**RE: Harnett County Land Use Application #10-5-23930**

The Harnett County Department of Public Health, Environmental Health Division on March 19, 2010, evaluated the above referenced property at the site designated on the plat/site plan that accompanied your existing tank application. According to your application requesting a 24 x 24 storage building, the evaluation was done in accordance with the laws and rules governing wastewater systems in North Carolina General Statute 18A.1950 including related statutes and Title 15A, Subchapter 18A, of the North Carolina Administrative Code, Rule.1950 and related rules.

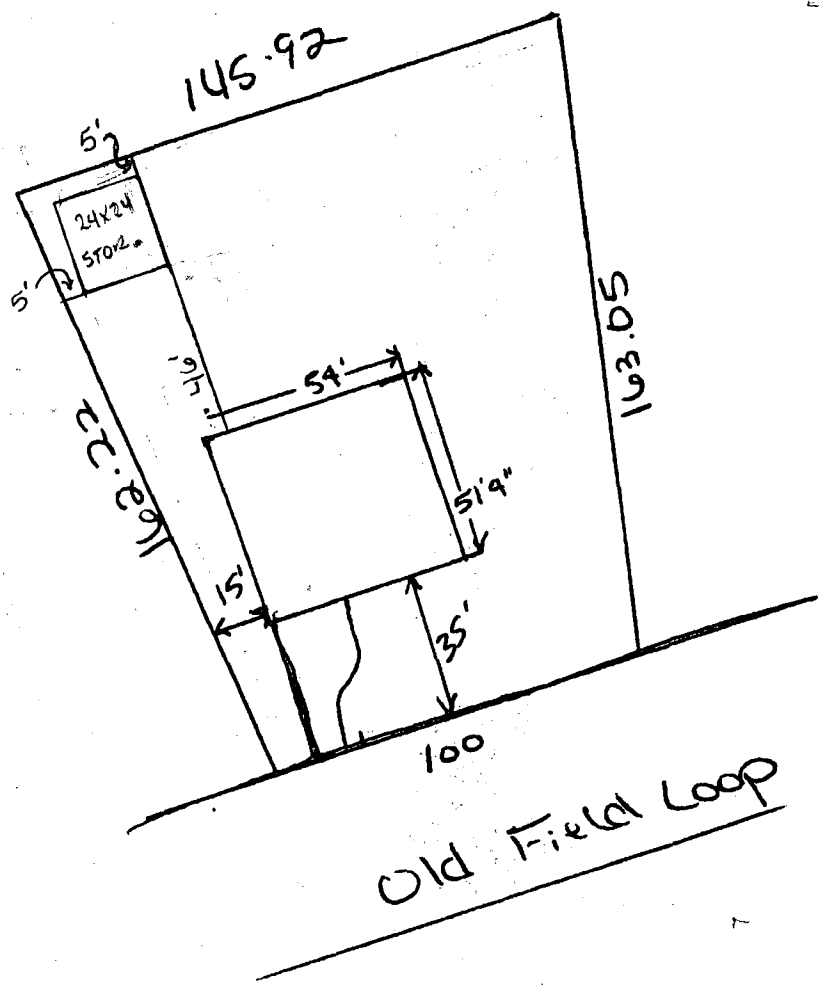
Based on the criteria set out in Title 15A, Subchapter 18A, of the North Carolina Administrative Code, Rules .1950, the evaluation indicated that the site is **UNSUITABLE** for the addition requested. Therefore, your request for an existing tank is **DENIED**. The site is denied based on the following:

- 15A NCAC 18A.1950a {16} - Any swimming pool must be 15' from any part of septic system.
- 15A NCAC 18.1945{b} - Each lot shall have original septic system plus repair area.
- 15A NCAC 18A.1950 {10} - Any building to be 5' from drain line.
- 15A NCAC 18A.1950{c} - Nitrification fields and repair areas shall not be located under paved areas or areas subject to vehicular traffic.

*Your proposed building will take up part of the repair area, and will be on top of part of your drain field. Also, you currently have an enclosed trailer parked on drain field.*
